## 23 Ocean Avenue - Preliminary Traffic Comments

Tom Errico &lt;thomas.errico@tylin.com&gt;

Wed, Jul 13, 2016 at 12:22 PM

Hi Nell – I have reviewed the application materials and offer the following preliminary traffic comments.

REINFORCED CONCRETE DRIVEWAY APRON
NOT TO SCALE

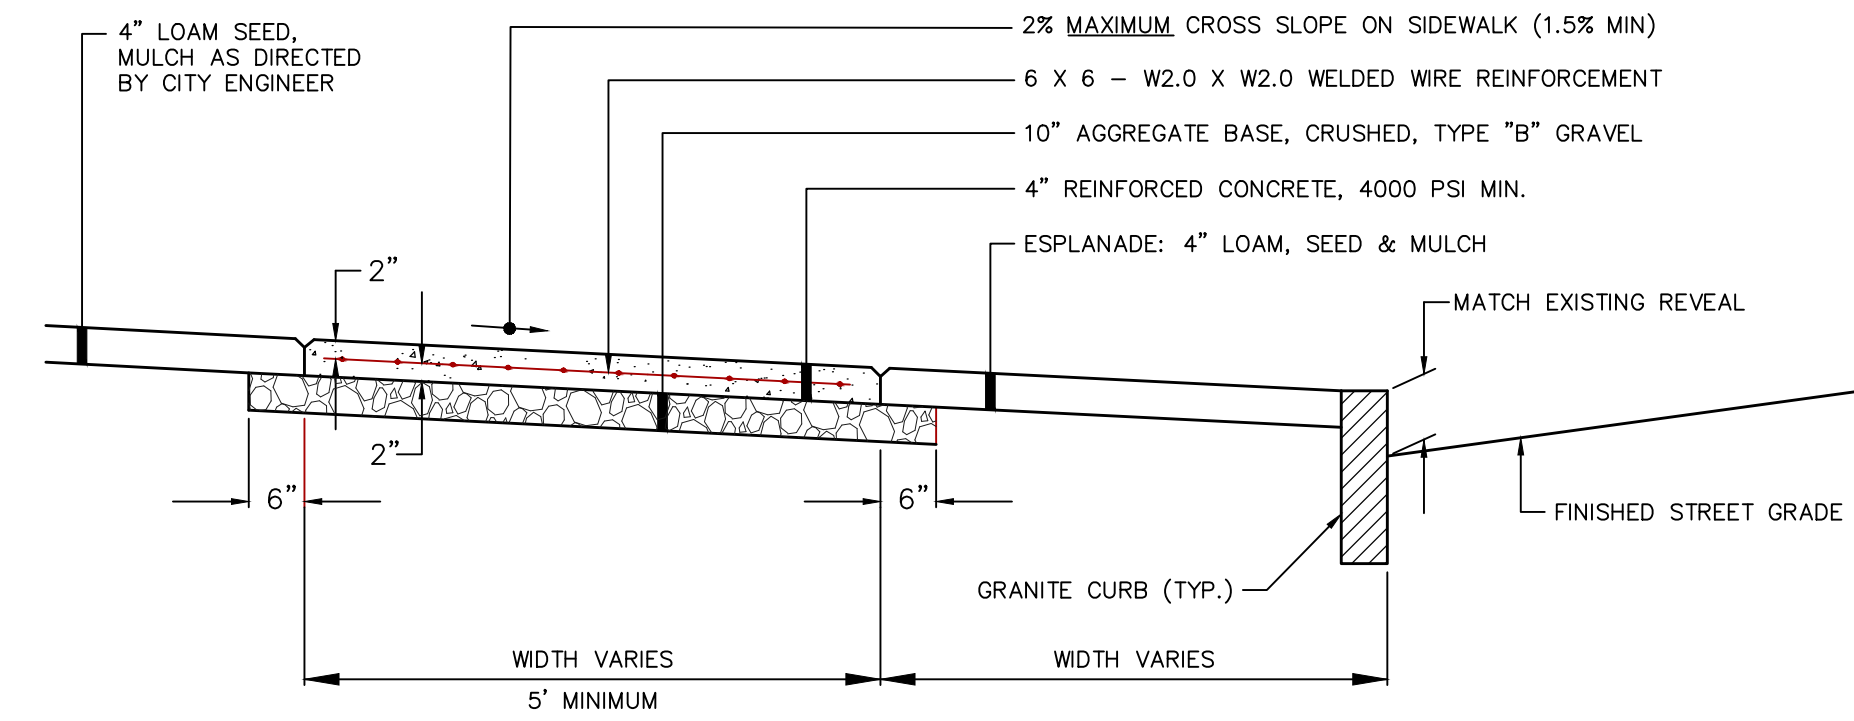
- A detail for the driveway shall be provided that notes that the cross-slope shall not exceed 2%.
- The plans do not include full replacement of the sidewalk on Ocean Avenue along the entire property frontage. The applicant should either include full sidewalk replacement or document justification for the current proposal.

3 SIDEWALK RAMP DETECTABLE WARNING TILE AND APEX RAMP
NOT TO SCALE

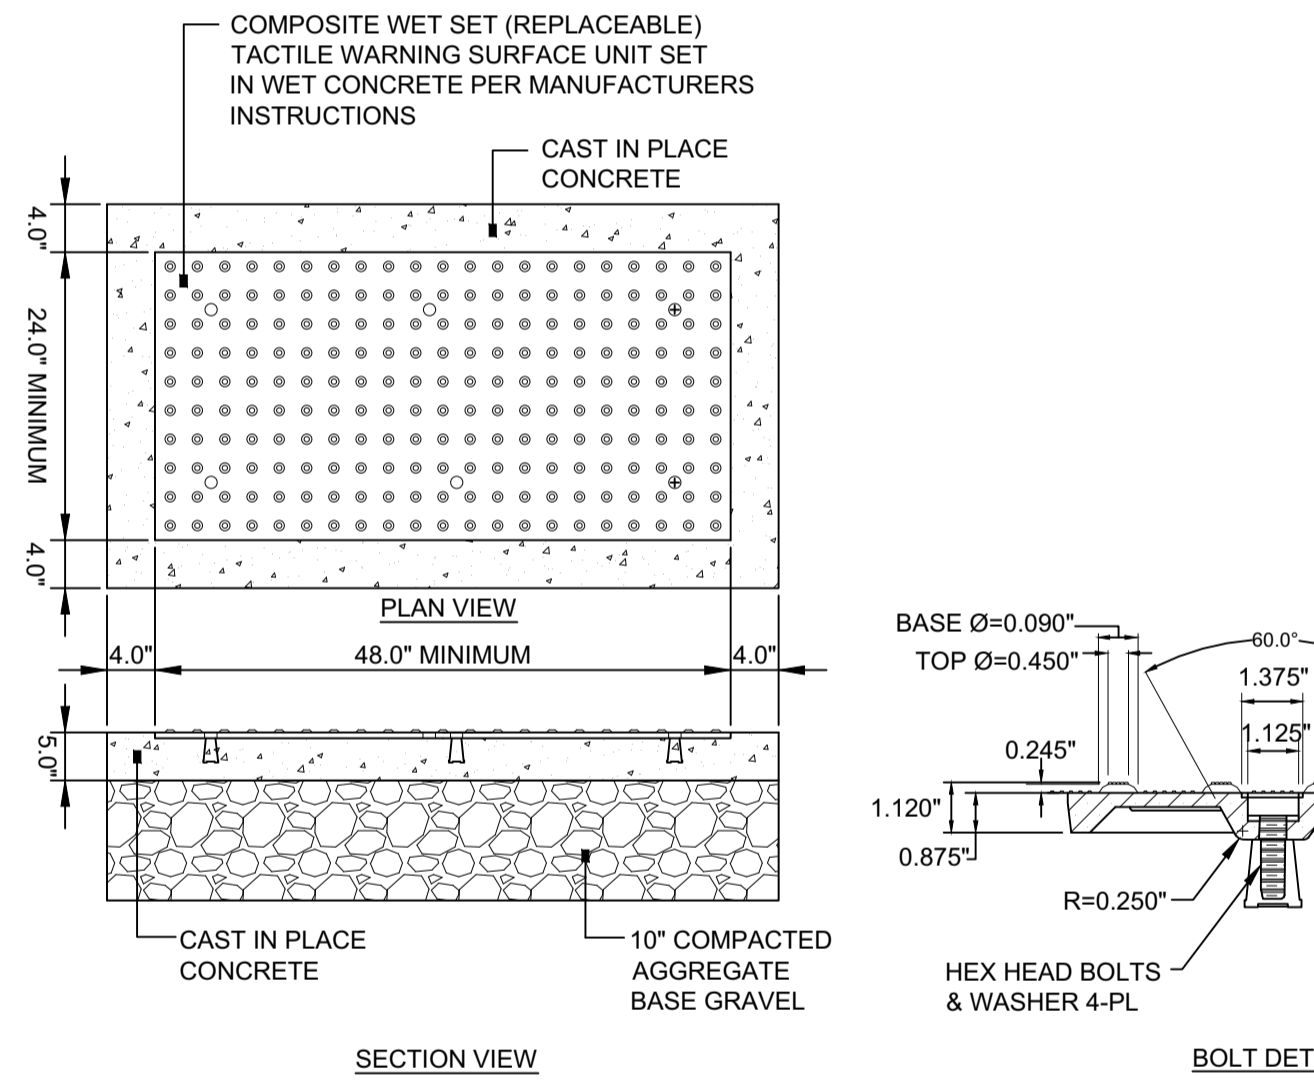
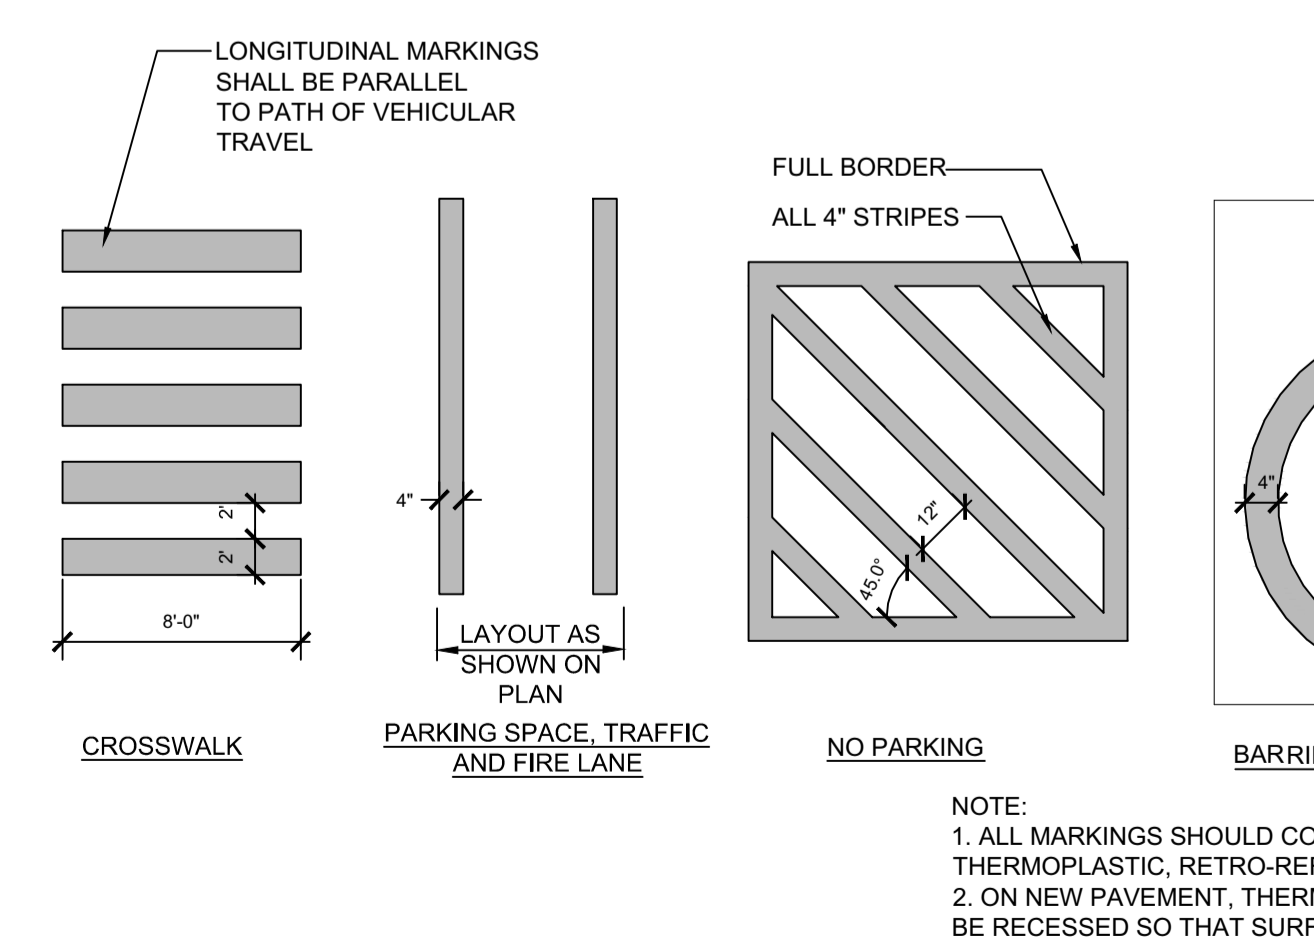
- Further review of the sidewalk ramp configuration is required. I would suggest that a fully ADA compliant ramp be provided on the opposite side of Hersey Street.
